Please ask for: Ms Iqraa Malik
Email: iqraa.malik@terraquest.co.uk
Telephone: 01212341390
Our Ref: Y/29/21/HH
Your Ref:
Date: 8th March 2021

Application for Planning Permission for Works or Extension to a Dwelling

Development: Erection of double garage
Location: Magnolias Church Lane Yapton BN18 0EH

BLOCK PLAN

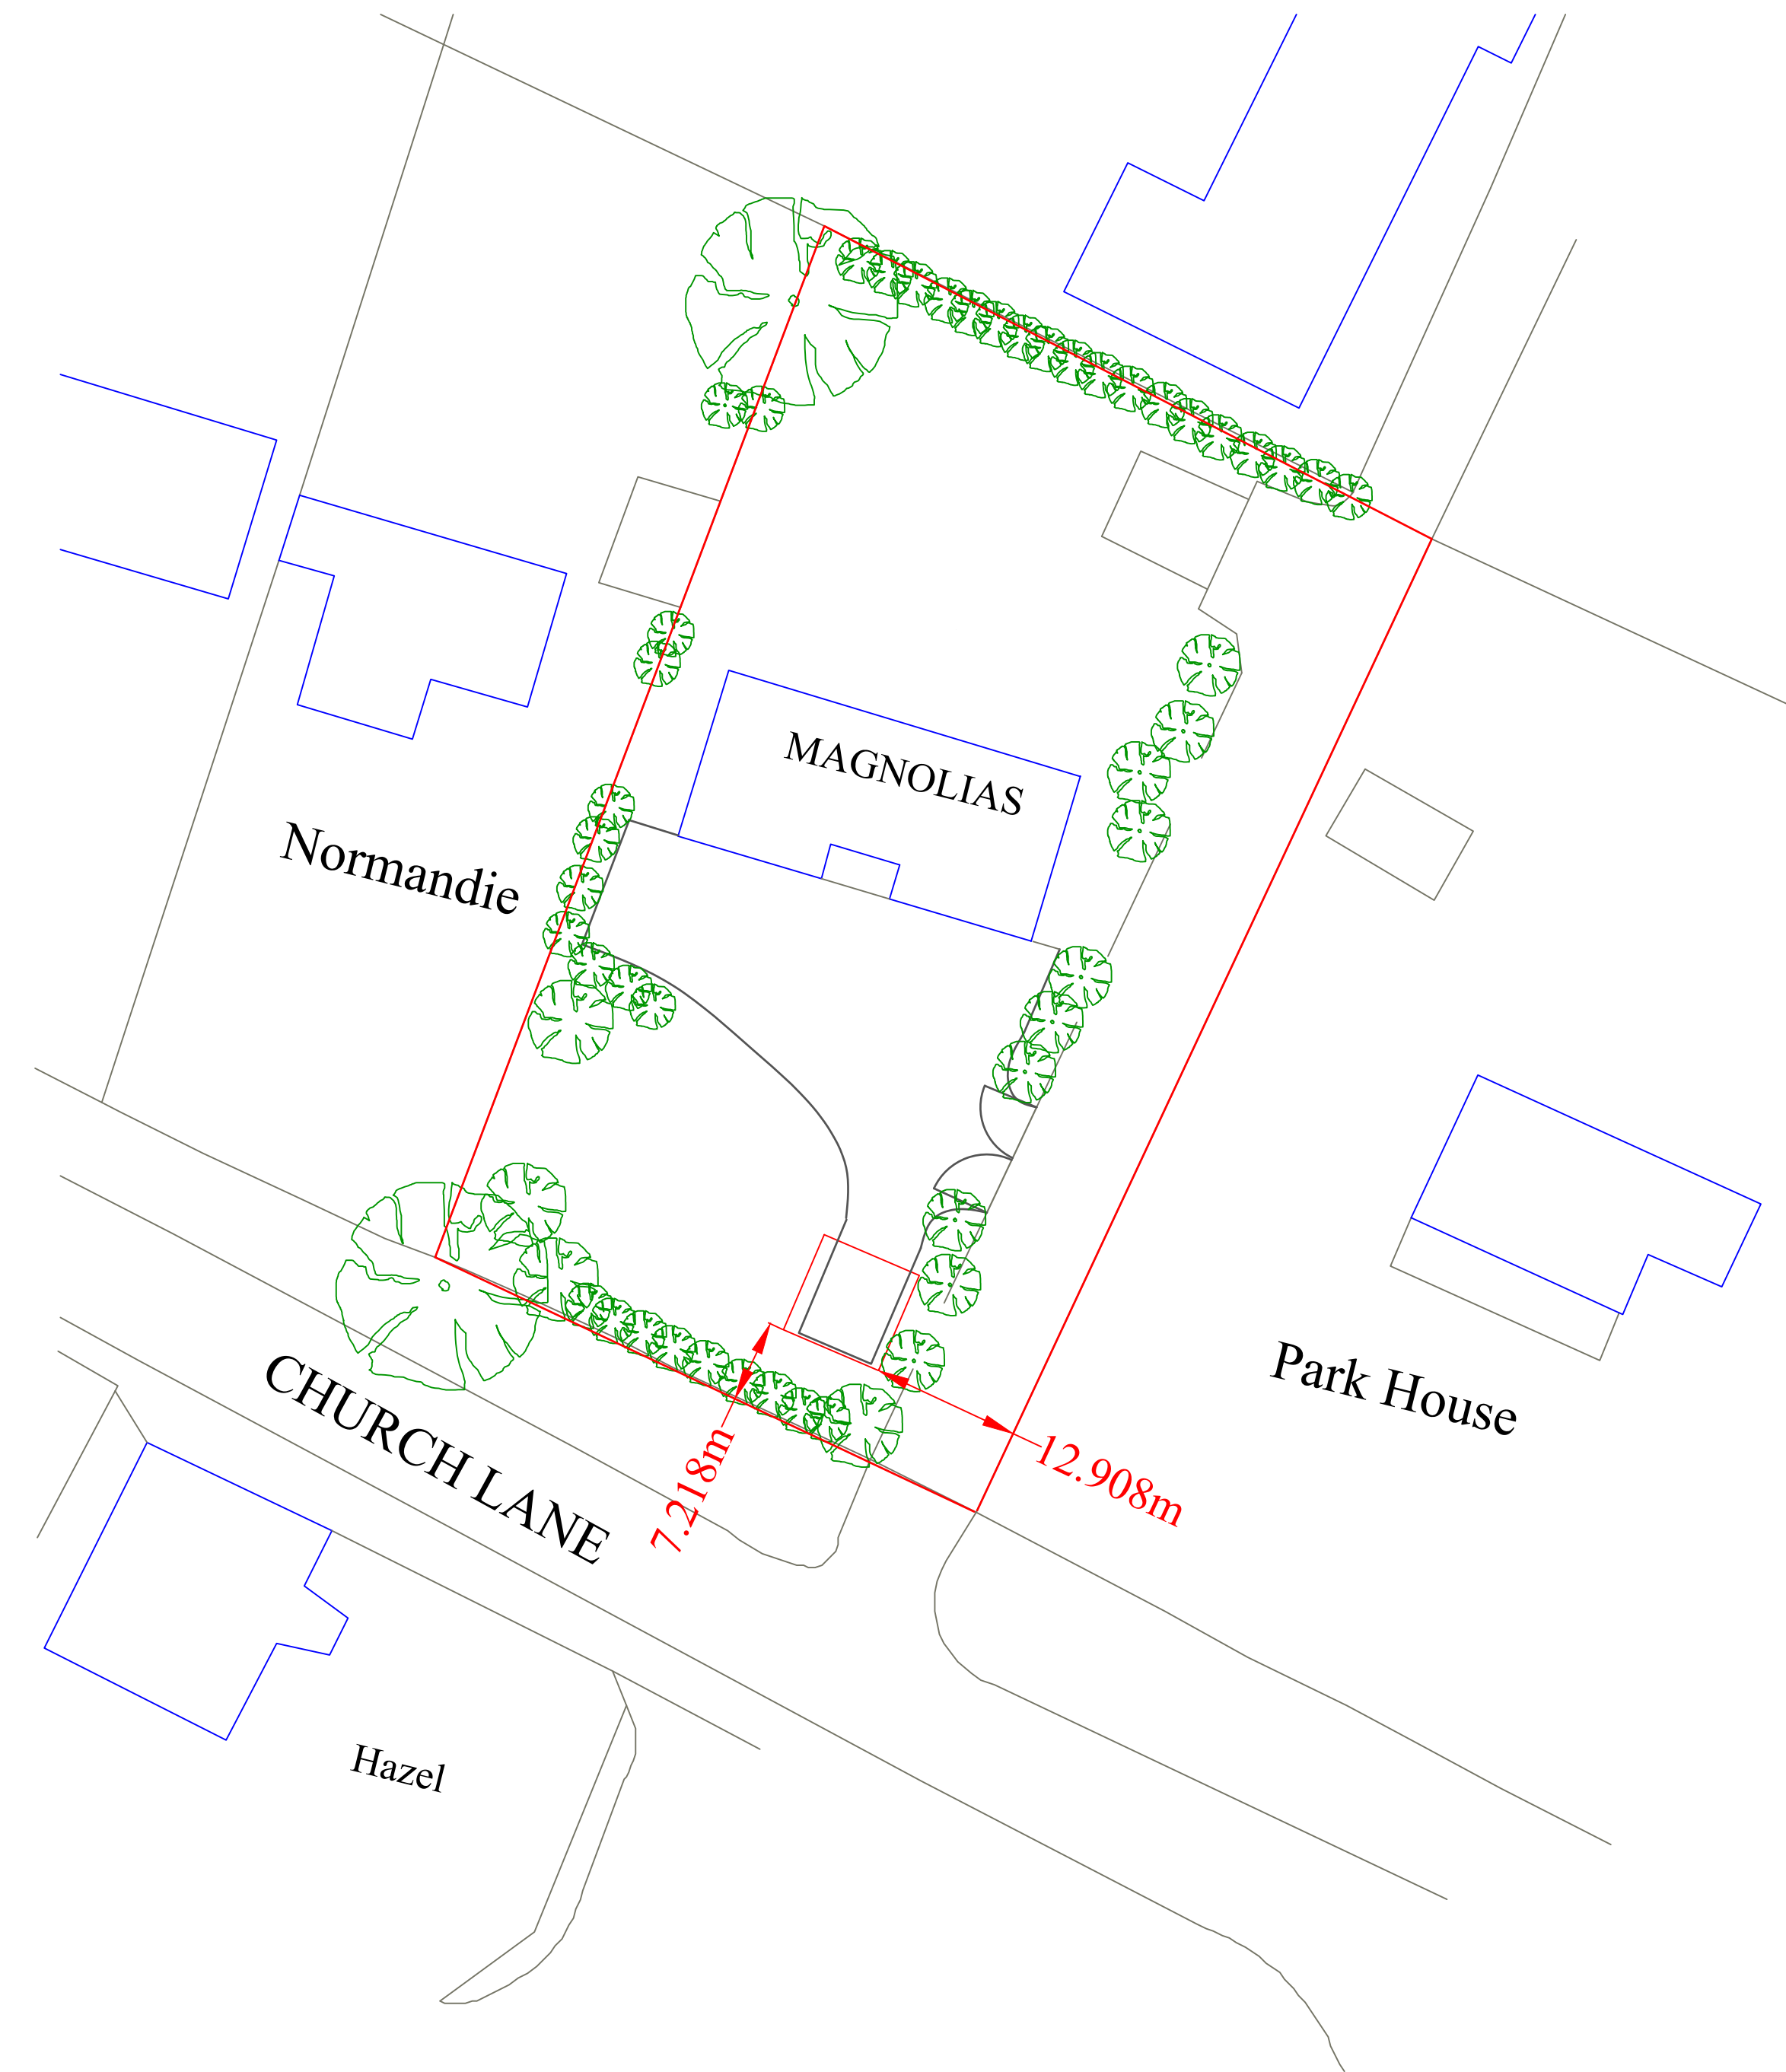
Block Plan

You are required to have dimensions from the proposed extension(s) to all site boundaries. Please amend.

Please add a scale bar to all plans.

GARAGE GENERAL LAYOUT

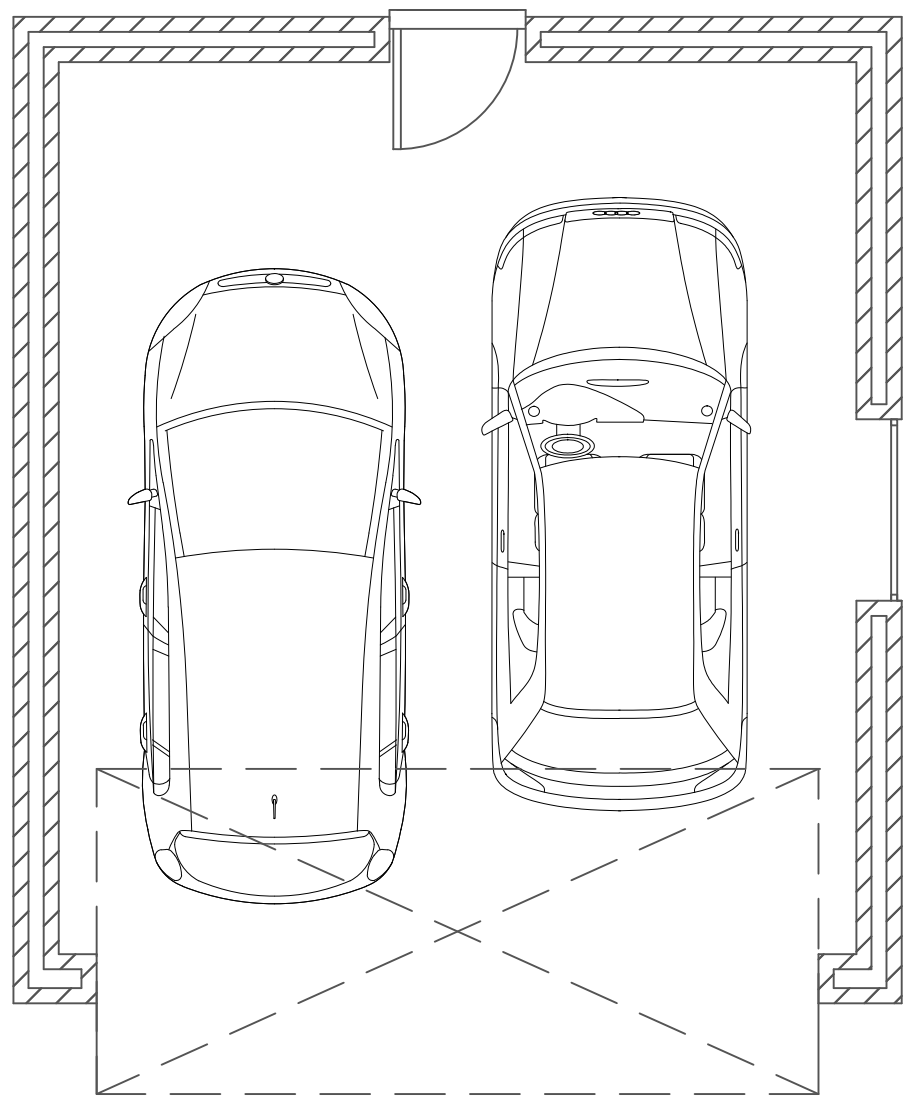
Please add a room label to the floor plan.

LOCATION PLAN

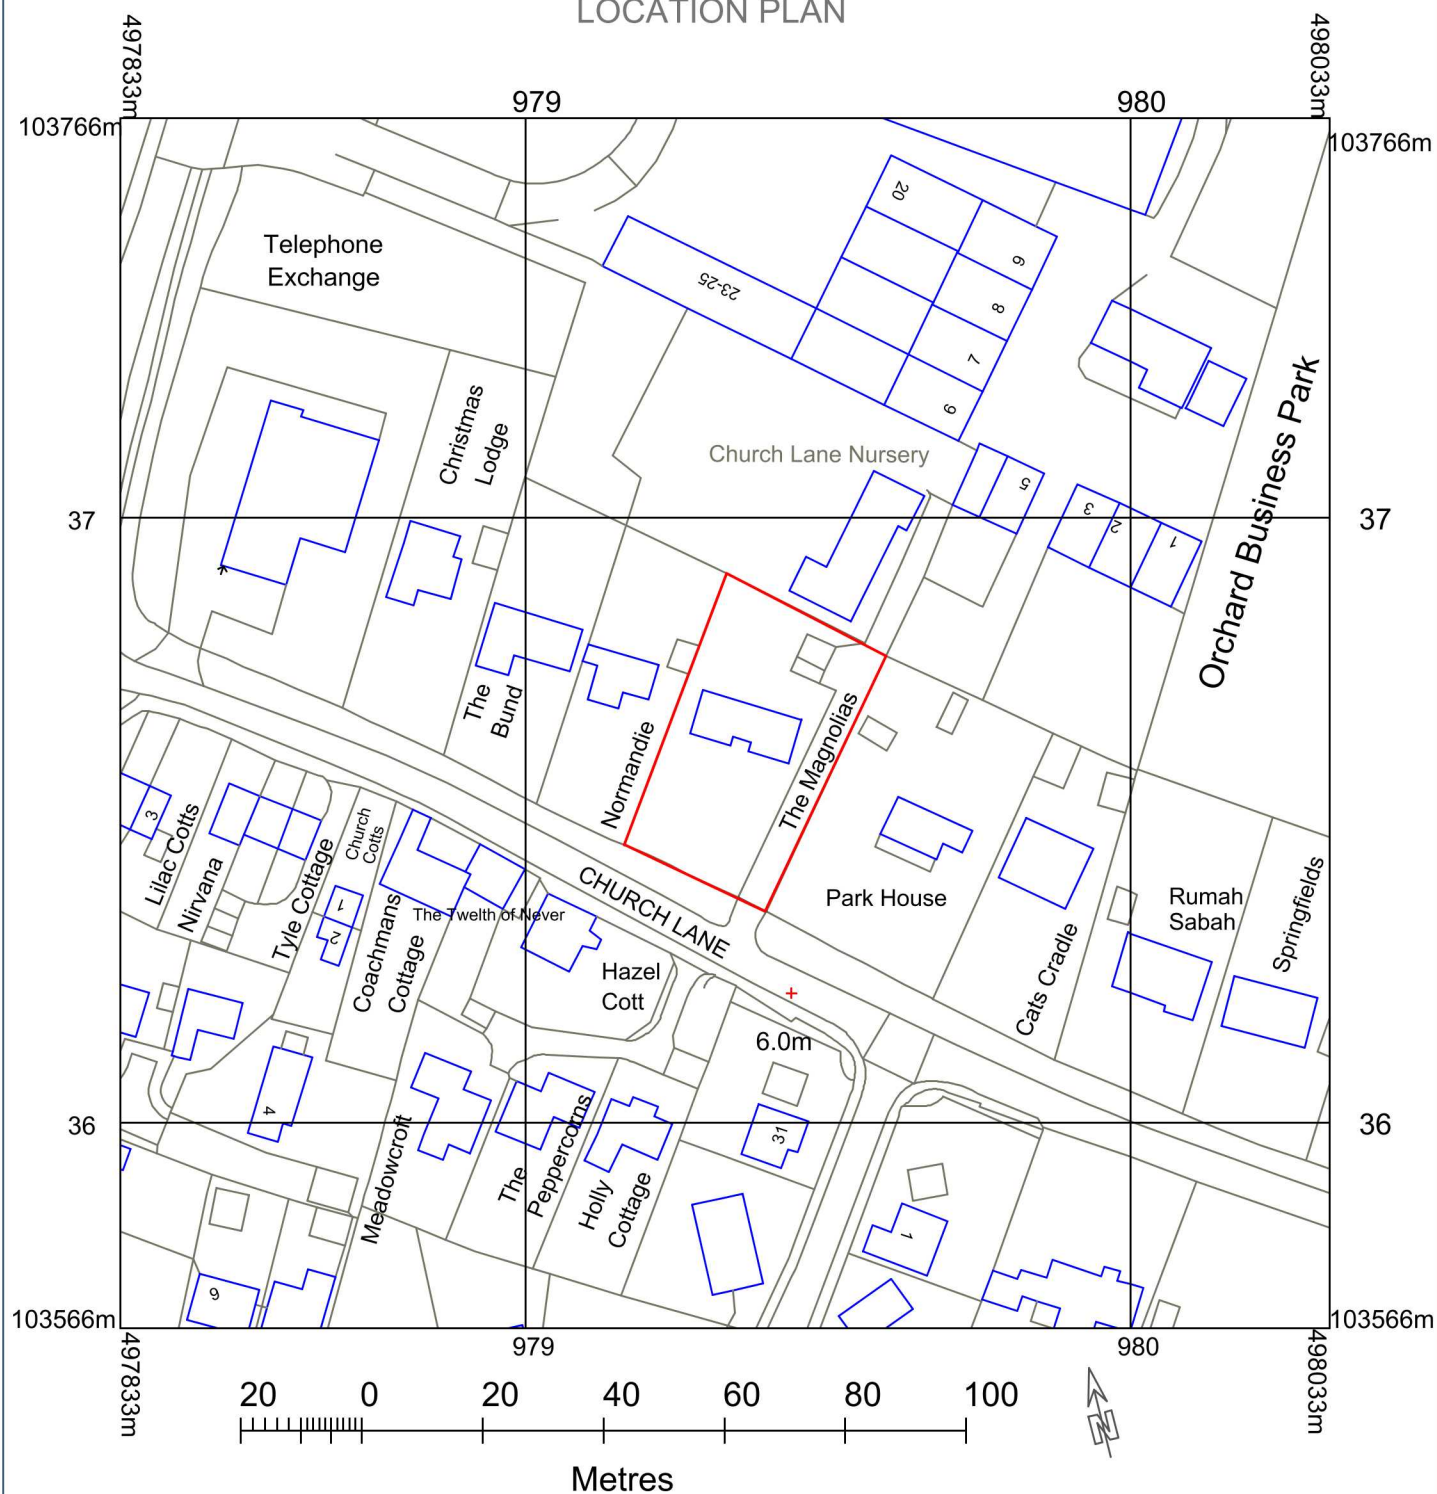
Location Plan

Please submit a copy of a location plan at a scale of 1:1250 with the site boundary outlined in red. Further details of what must be included on the plan can be found in the Validation Requirements List.
